From: Nicola Moore on behalf of Planning.Responses
Sent: 13 November 2019 09:46
To: Planning Scanning
Subject: FW: Planning Consultation on: BN/65/19/OUT

Comment from Greenspace

APPLICATION NO: BN/65/19/OUT

Site Address: Bexstone House Barnham Road Eastergate PO20 3RT

MAP FILENAME : **Bex/TSP/01/18**

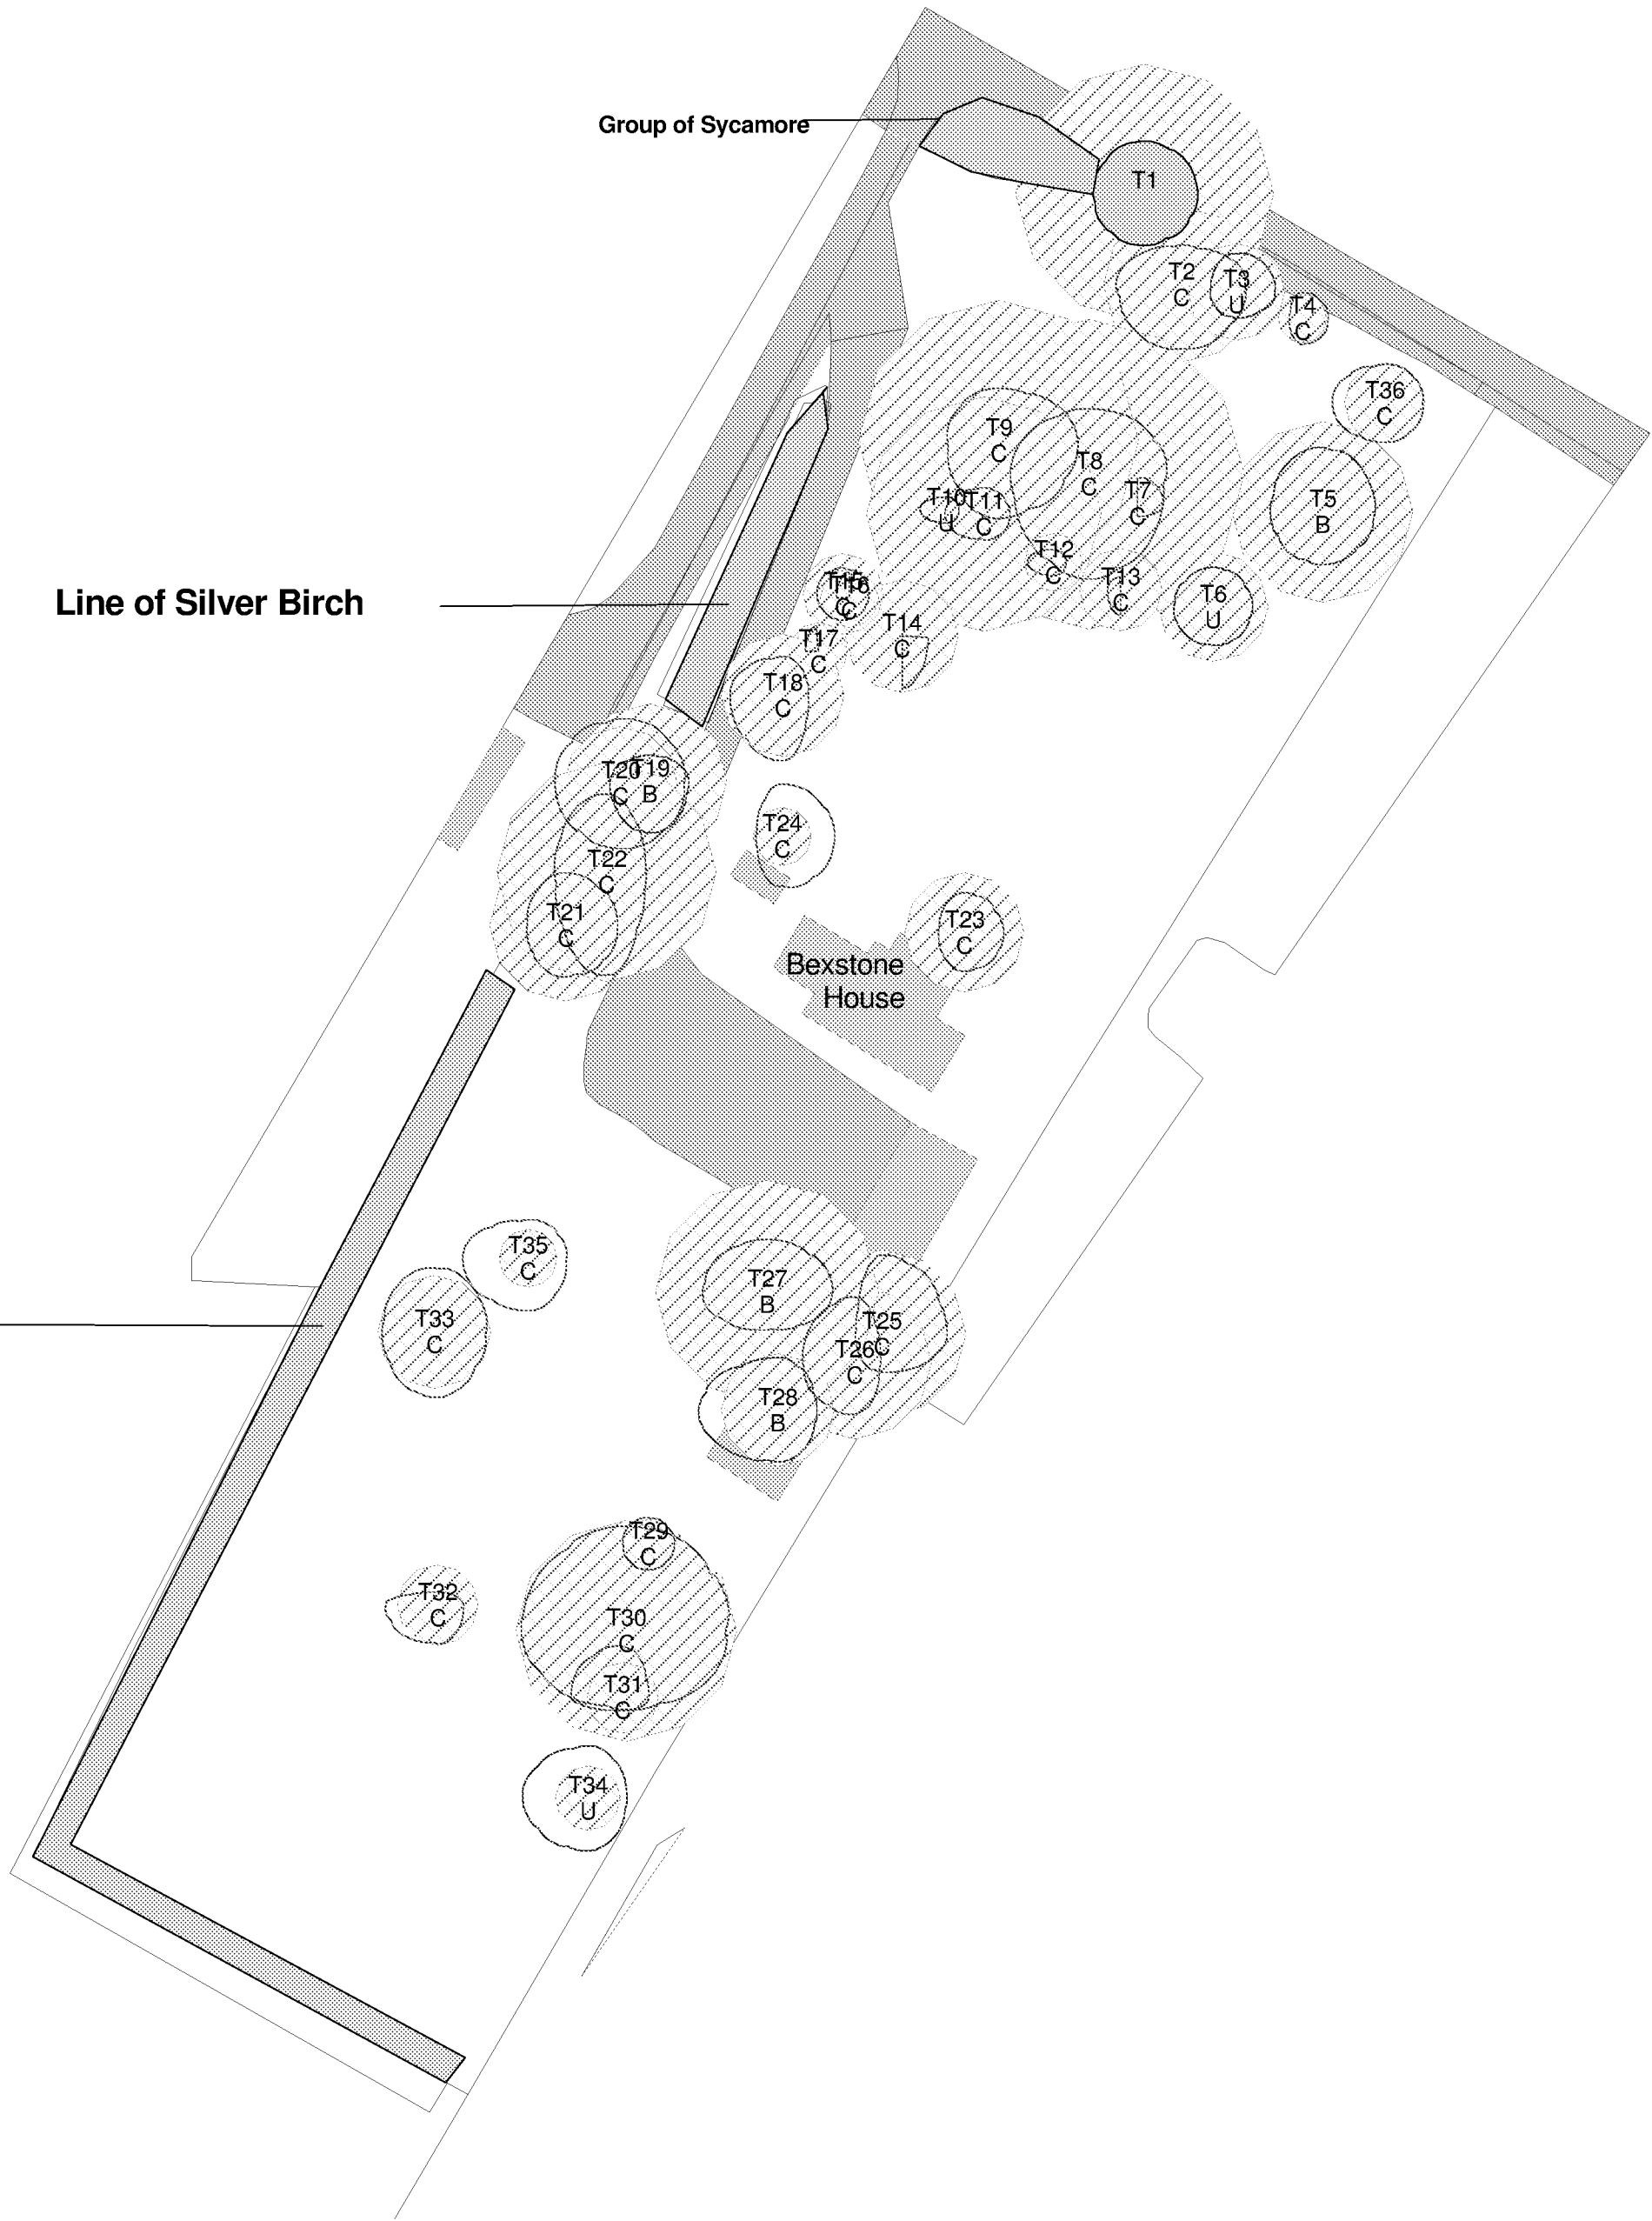
There has only been an indicative layout submitted and we would need to see detailed planting plans submitted or conditioned with any decision. It would appear from the layout that significant tree removal would be required to facilitate this development as proposed. Trees to be retained where shown to be in the gardens of private dwellings have the potential to be put under pressure to be pruned or removed, so layouts should consider any existing or to be retained features before mapping the sites layout.

Existing trees or vegetation that fall within the proposed or periphery of the development, may provide significant aesthetic impact to the location. Trees in particular along the boundaries, which adjoin neighbouring properties could provide potential valuable screening and should be protected and retained. Any considered tree works within the site should be agreed with Arun District Councils Tree Officer. Any adjacent trees associated with this location and offsite that may have roots within the development area should be subject to tree protection measures.

I conclude some landscape concern re the potential to protect and retain the existing trees and also that the open space is limited in which to allow sufficiently for a robust planting scheme to be implemented. The retention of the open space to the entrance of the site setting back the development from the B2233
